A57 Link Roads

**8.3 Statement of Common Ground with
High Peak Borough Council**

8.3 STATEMENT OF COMMON GROUND WITH HIGH PEAK BOROUGH COUNCIL

**Table 3.1: Statement of Common Ground (SoCG) Between National Highways and High Peak Borough Council (HPBC)
 Table of Issues/Matters - Final Version dated 16 May 2022.**

**6.4 Environmental Statement
Figure 5.1 Air Quality Constraints Map**

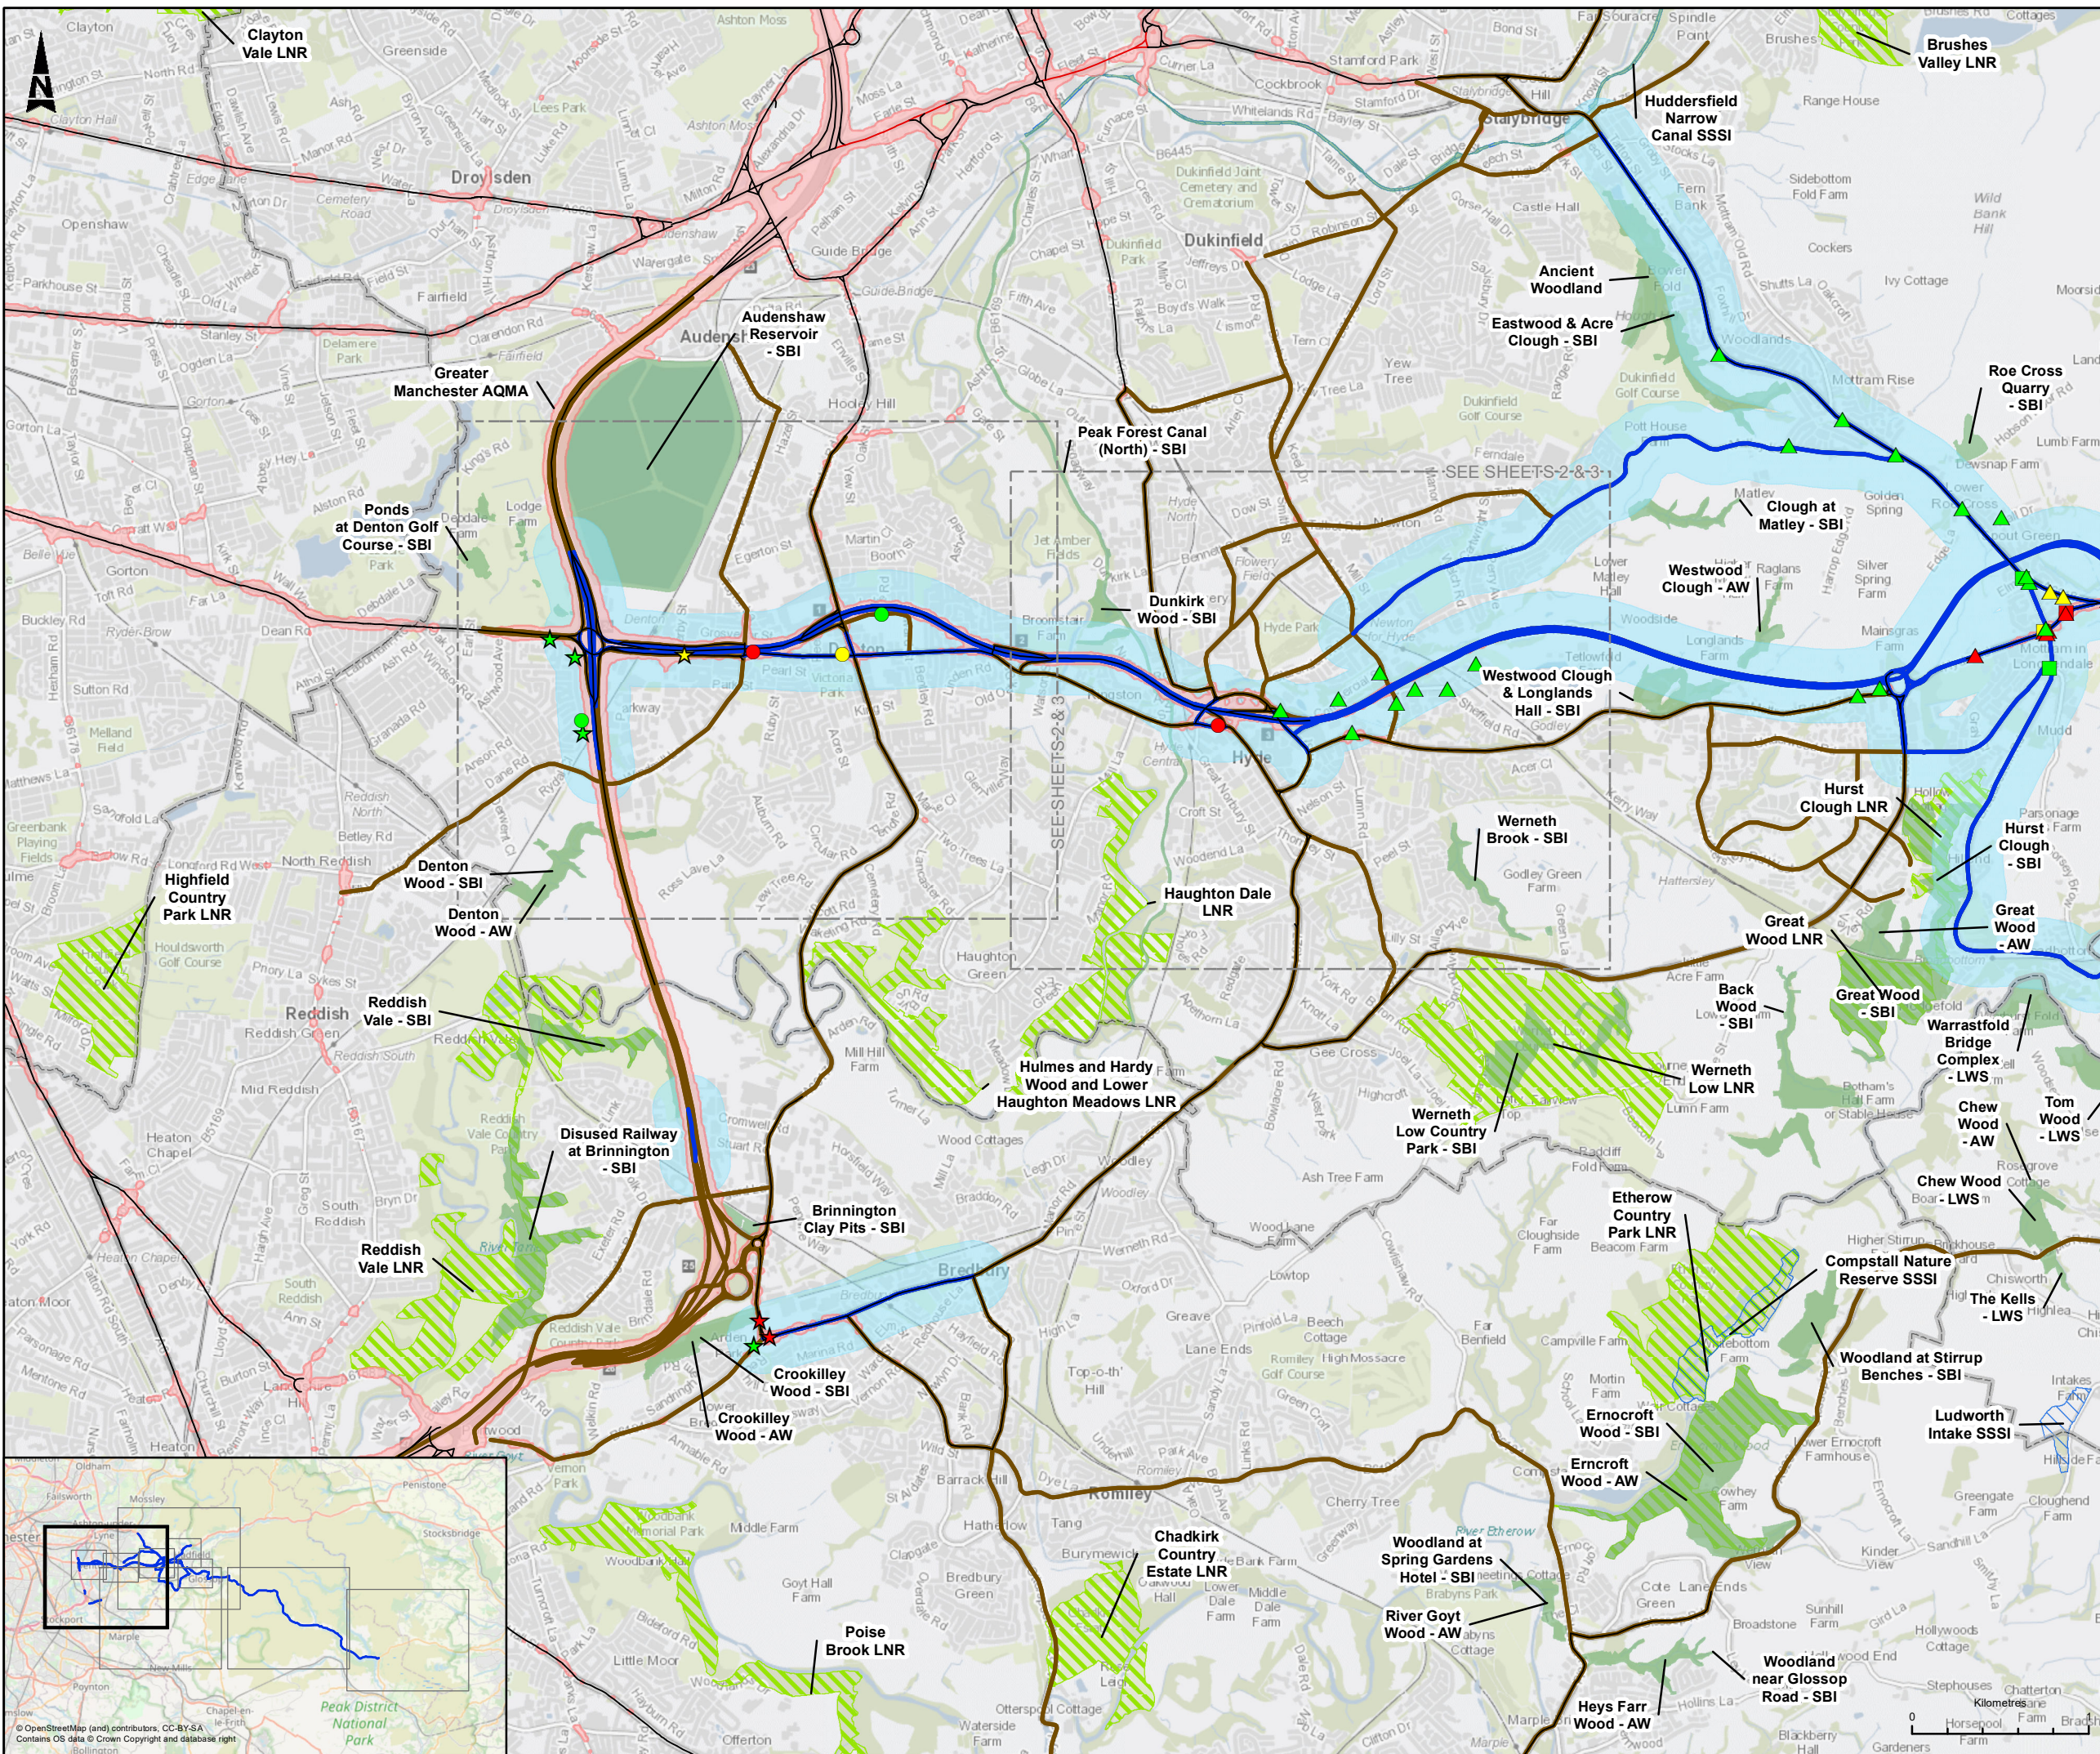
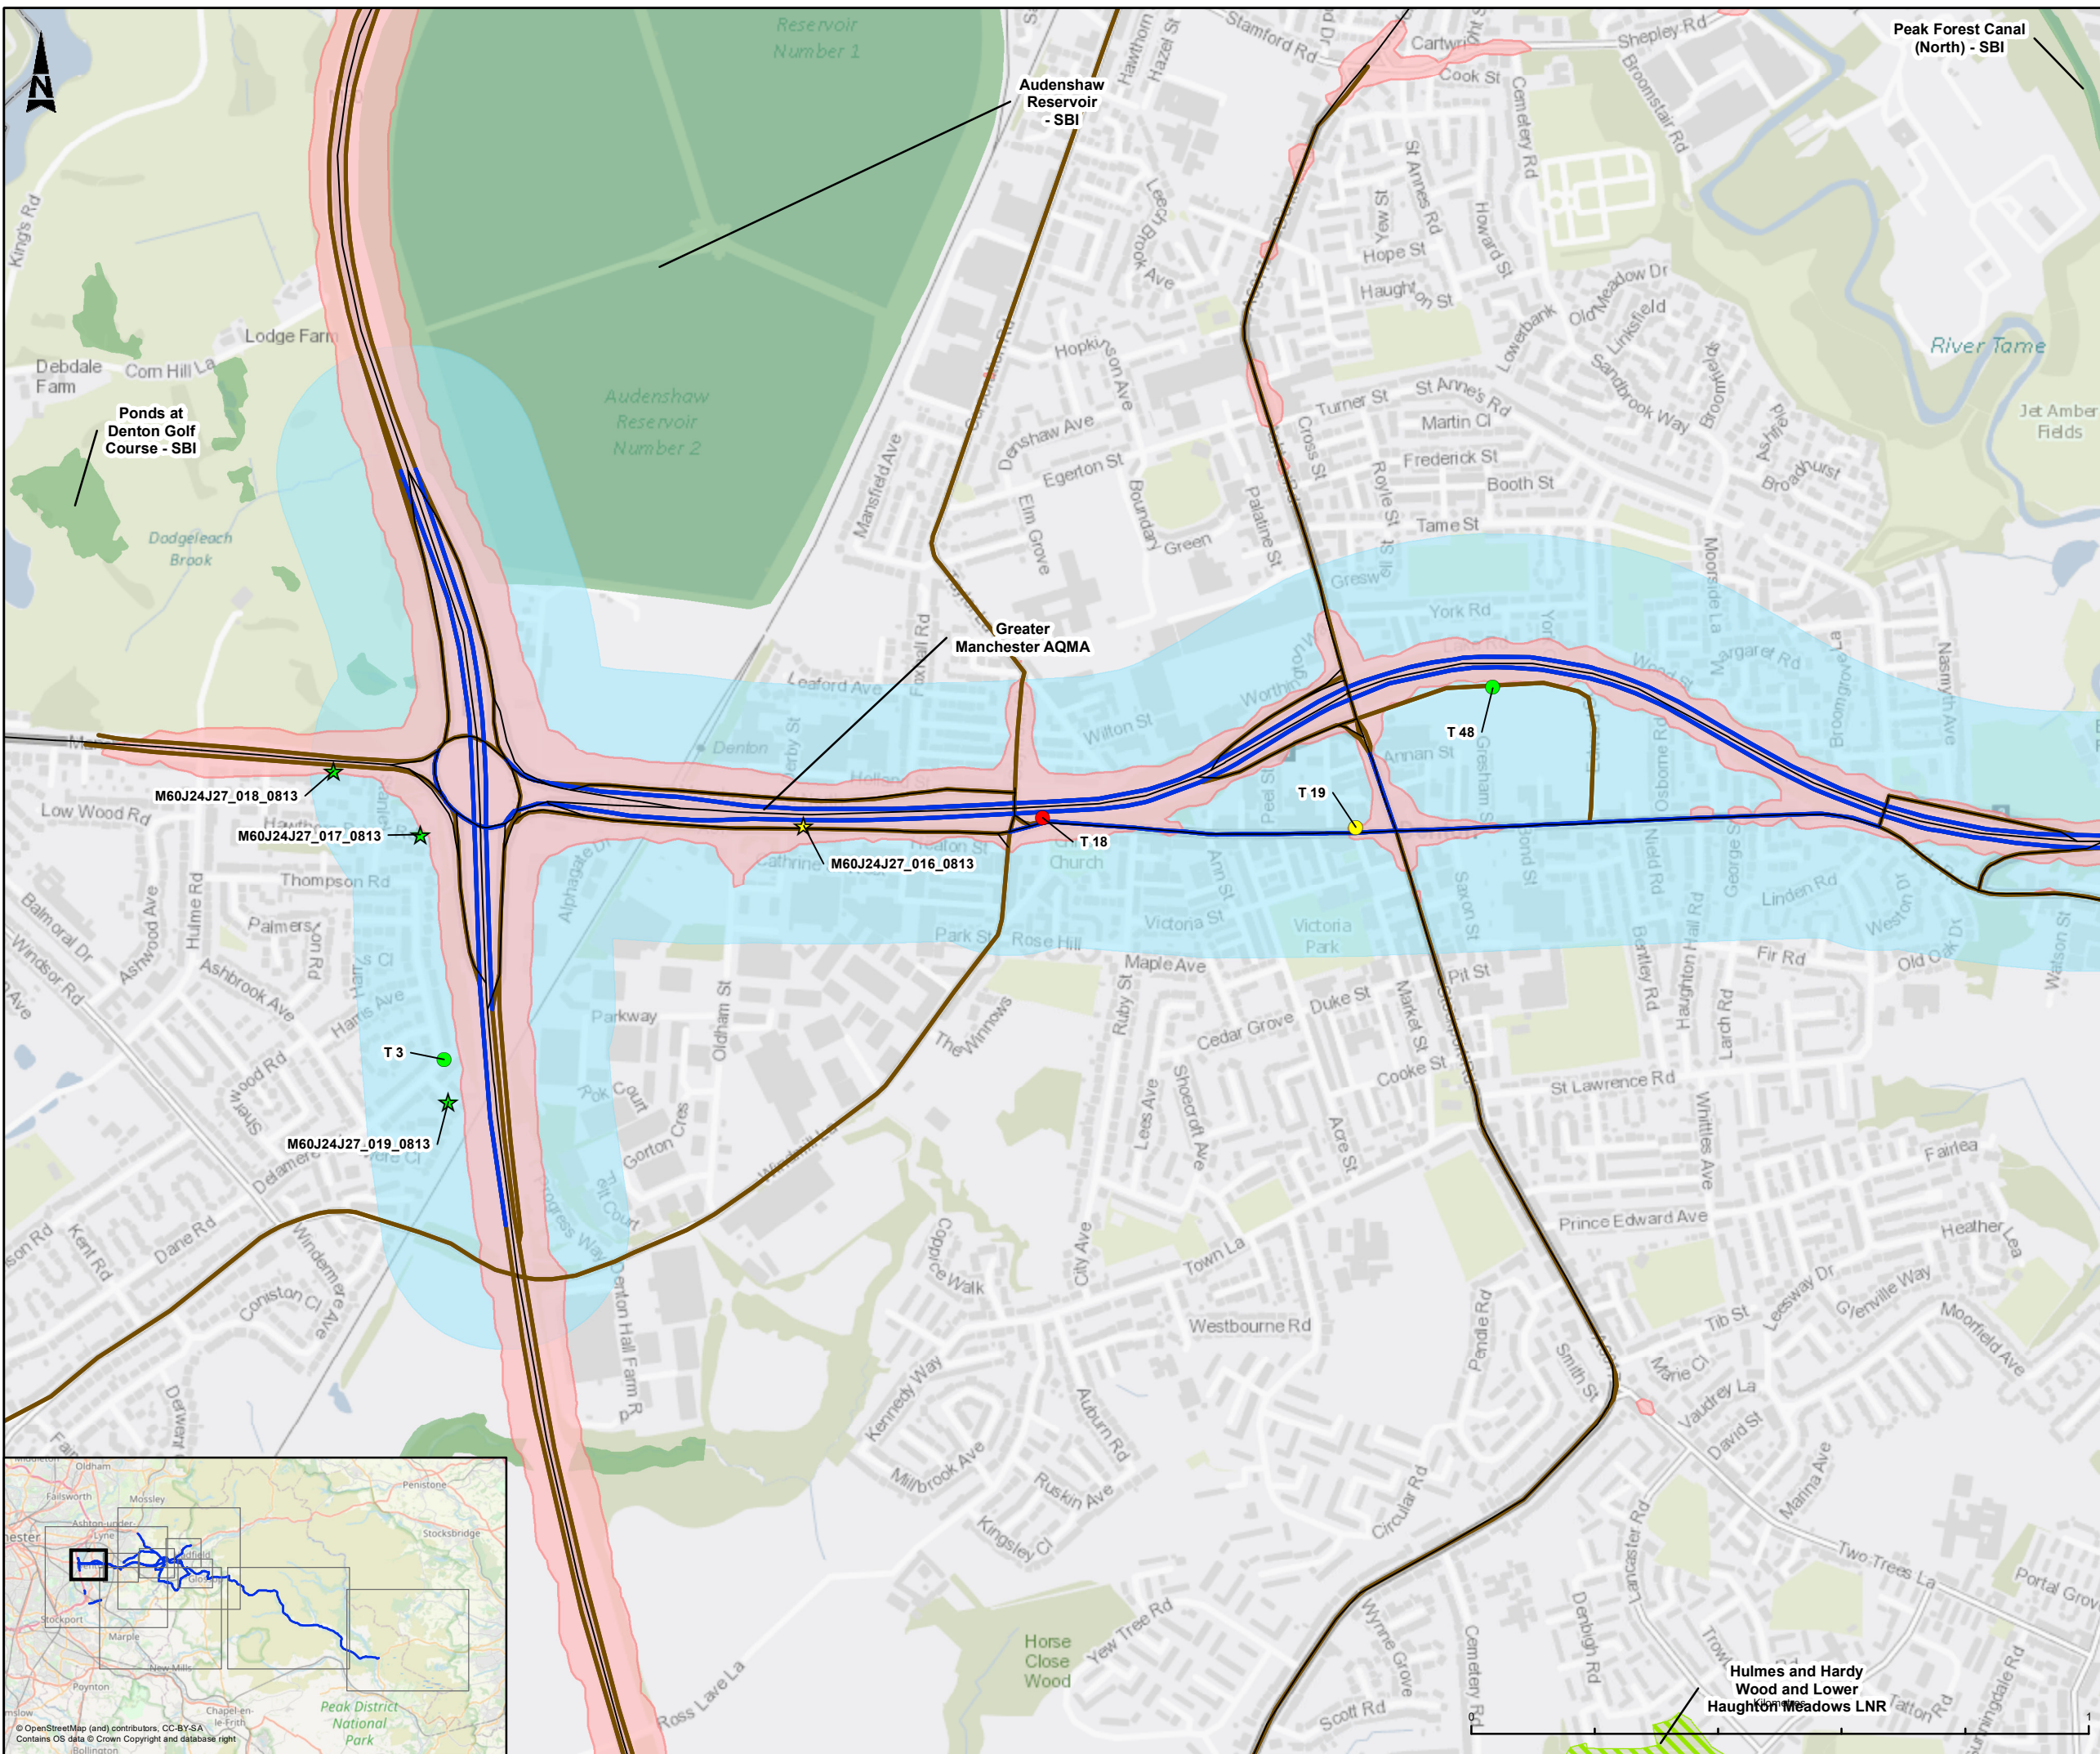
3.1	Environmental Statement (ES) [APP-061]	Air Quality Methodology AQMA's	The Consultee stated that air quality is a major concern. Since the last public consultation on the scheme in 2018, HPBC has designated Air Quality Management Areas (AQMA's) on sections of the A628 in Tintwistle and the A57 at Dinting. Detailed assessment is required.	The Applicant's air quality assessment (in the ES [APP-061]) has taken into consideration the AQMA designated since 2018 in Tintwistle and Dinting Vale. The air quality assessment has been undertaken in accordance with DMRB LA105 with the air quality study area determined on the basis of traffic change criteria given this guidance.	Agreed

3.2	Environmental Statement (ES) [APP-061]	Air Quality Methodology Dinting Vale	The Consultee questioned the air quality results at Dinting Vale.	The air quality assessment has been undertaken in accordance with DMRB LA105 with the air quality study area determined on the basis of traffic change criteria given this guidance. A detailed assessment of air quality has been undertaken for all areas where traffic changes are expected, which includes the Dinting Vale area. Full results will be reported in the Environmental Statement [APP-061].	Agreed
